HOMESTEAD NORTH AT
STERLING RANCH

EARLY GRADING & EROSION
CONTROL PLAN

SHEET 3 OF 5

SHEET 3 OF 10
JOB NO. 25188.00

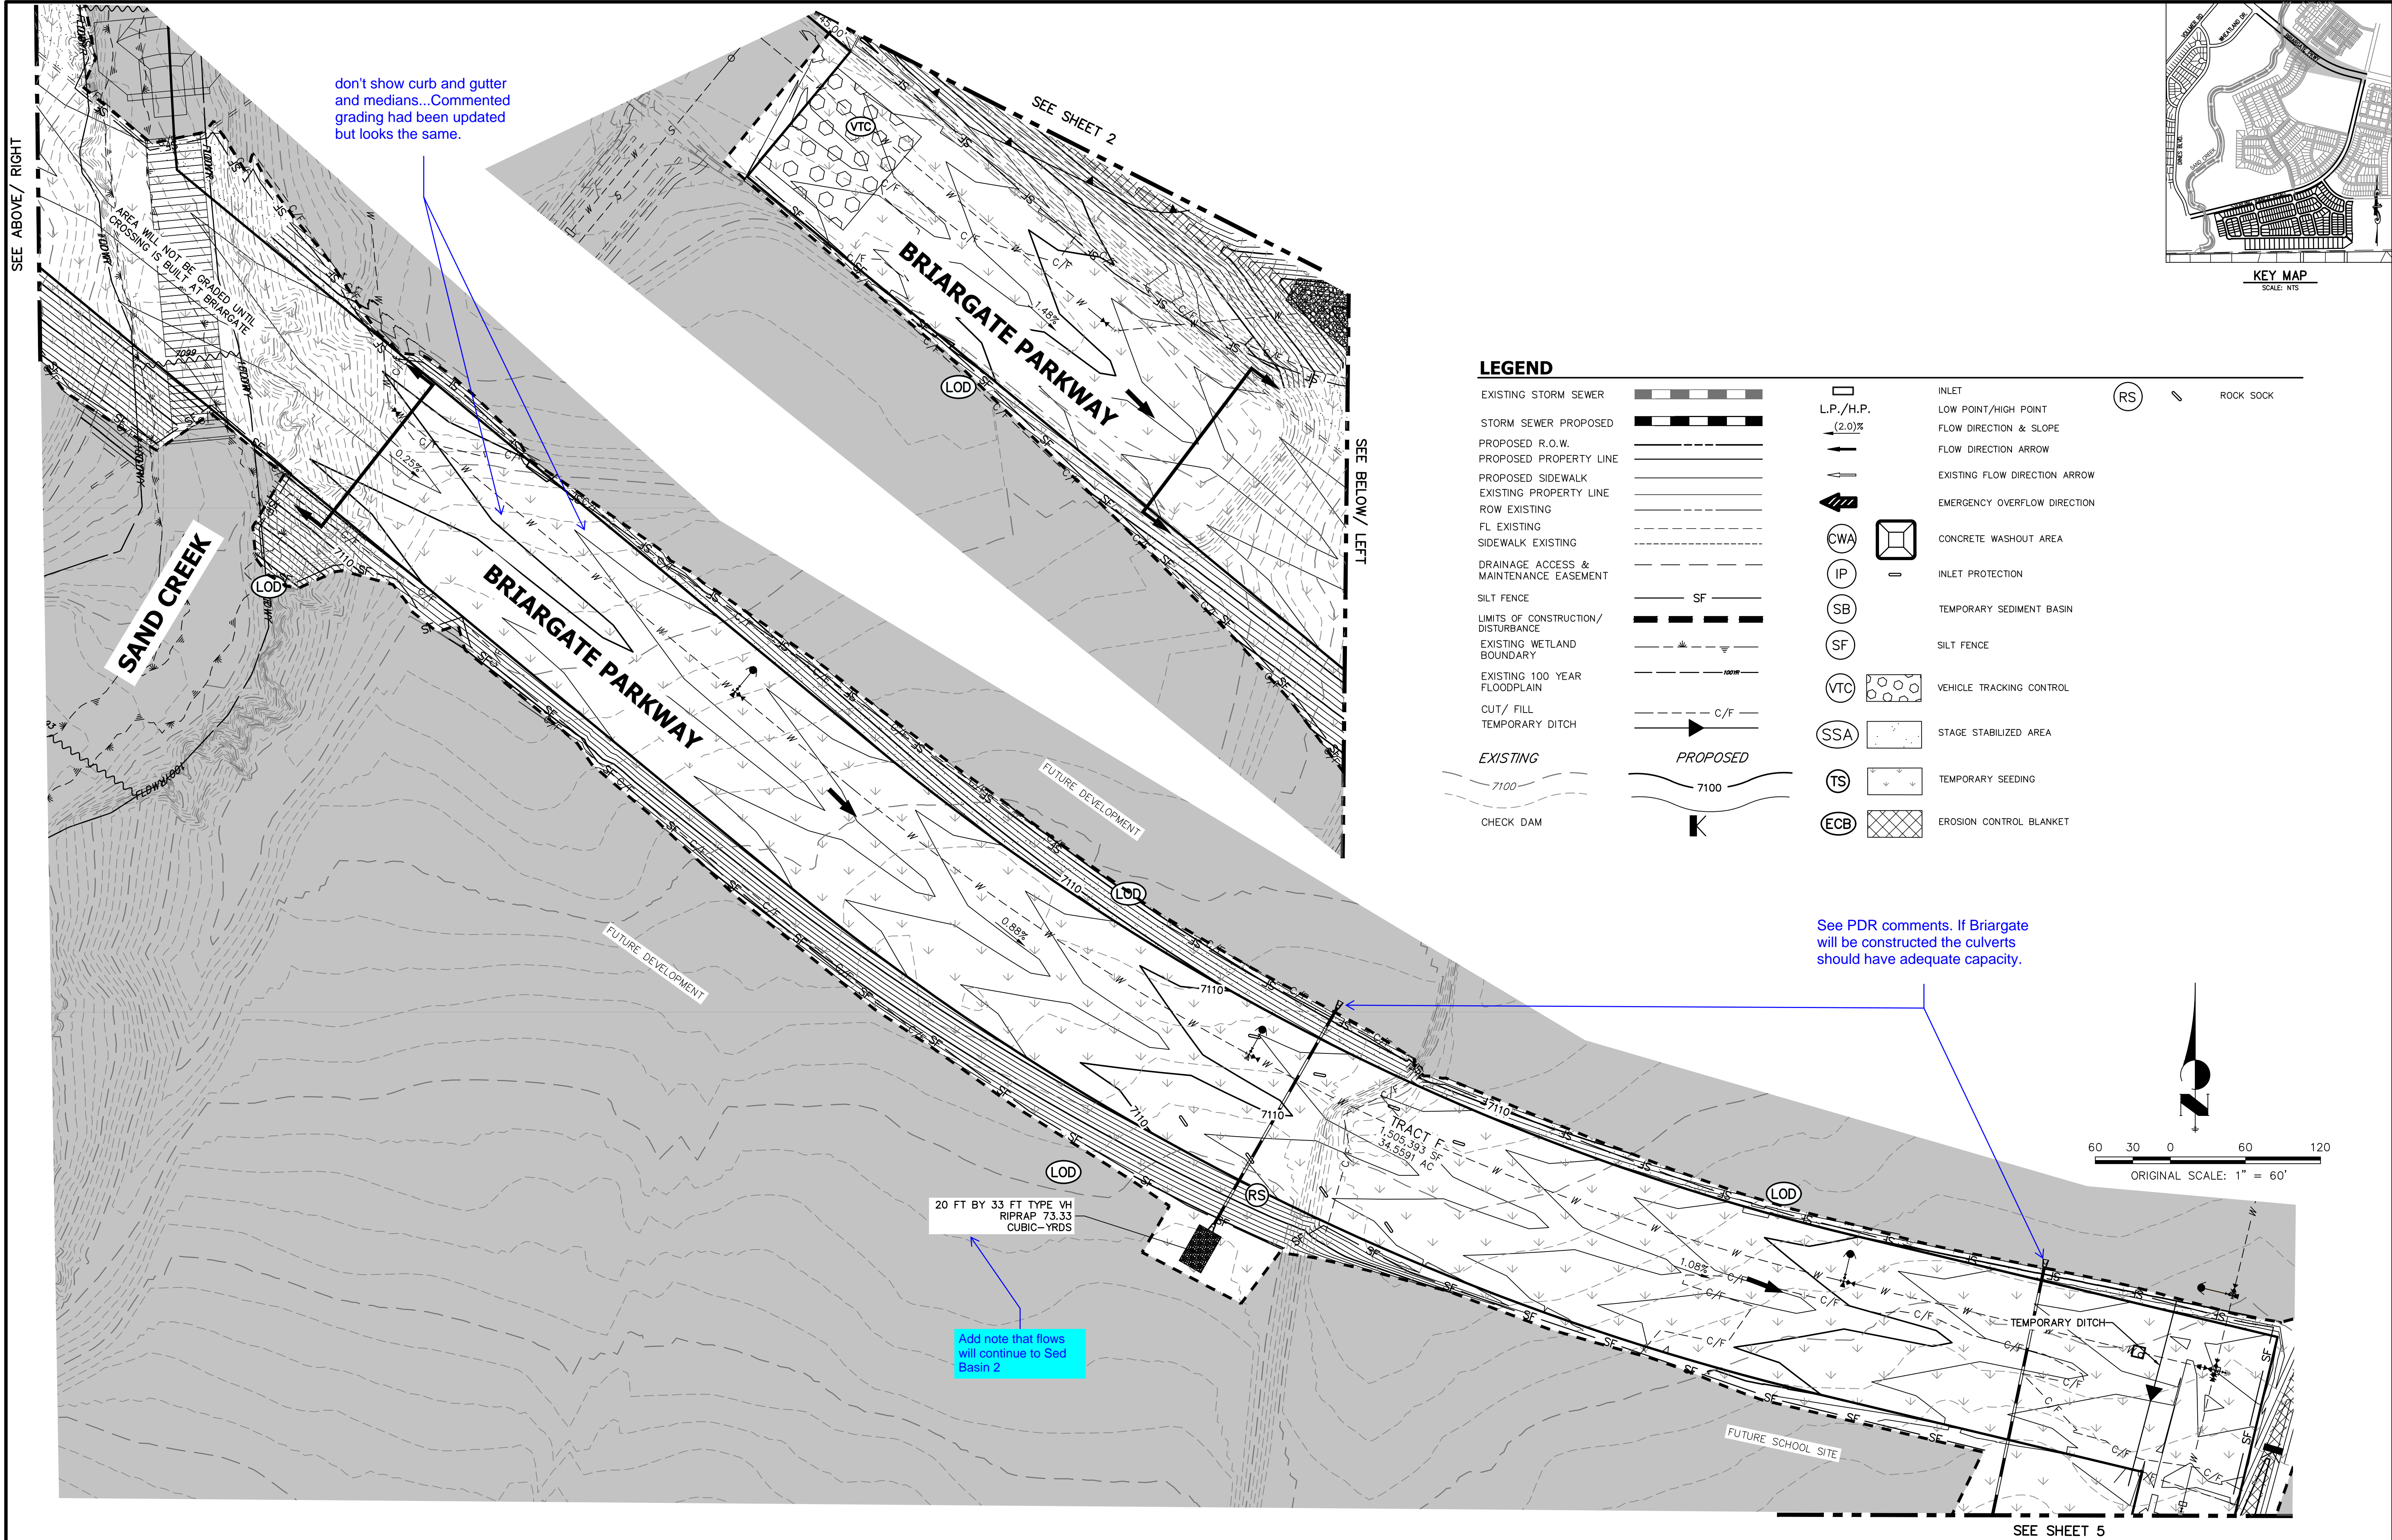
If the same as the limits of disturbance, change to "limits of construction/disturbance" or add "limits of disturbance" to the legend and figure

JR Response: Addressed
